February 6, 2024

**Re: Mesa Del Sol Montage 7  
Erosion and Sediment Control Plan  
Engineer's Stamp Date 1/31/24 (R16E100A)**

Based upon the information provided in your submittal received on 1/31/24, the ESC Plan cannot be approved for Building Permit until after the following comments are addressed.

TEMPORARY EROSION AND SEDIMENT CONTROL PLAN

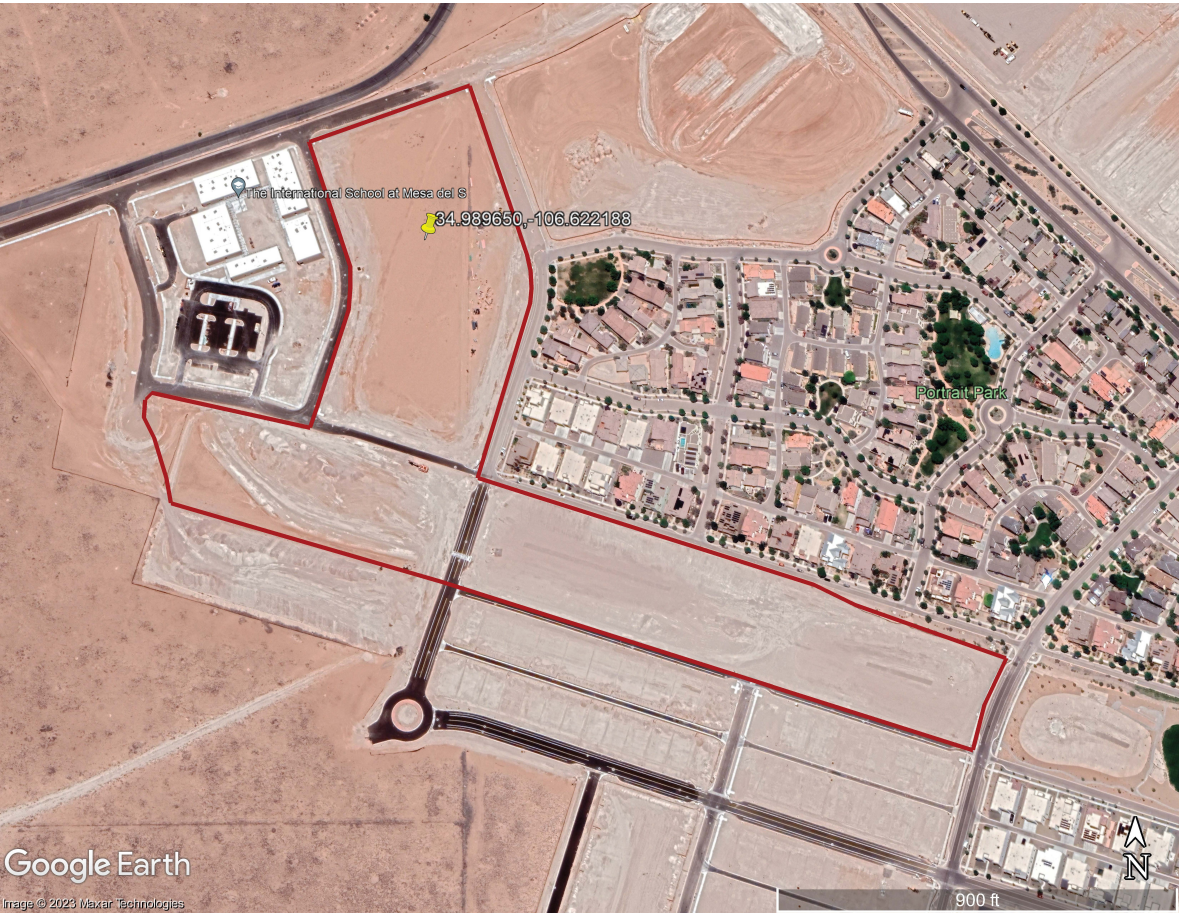
1. The Standard City Notes on this ESC Plan have been outdated since 6/16/23. See the new notes attached.
2. Perimeter retaining walls are shown in the Grading Plan approved by Hydrology yesterday for Building Permits, and the sidewalks and landscape strips around the perimeter are supposed to be constructed with the Work Order. Add a note and detail(s) addressing the sequence of construction, walls, sidewalks, and ROW landscape swale showing the location of the perimeter controls in each phase.

3. The sidewalks and landscape strips between the sidewalk and the curb will be constructed as part of the Work Order next to Parcels D, F, G, and H, so the perimeter controls that are shown next to the curb on Parcels D, G, and H must be re-located to behind the sidewalk.

4. The silt fence should not end at the low spot and must be extended uphill at Parcels D and F. Similarly, the perimeter controls are not appropriate across the concentrated flow paths in the two concrete channels on Parcels A and K, so the low corners of the controls there must be extended uphill to the east.
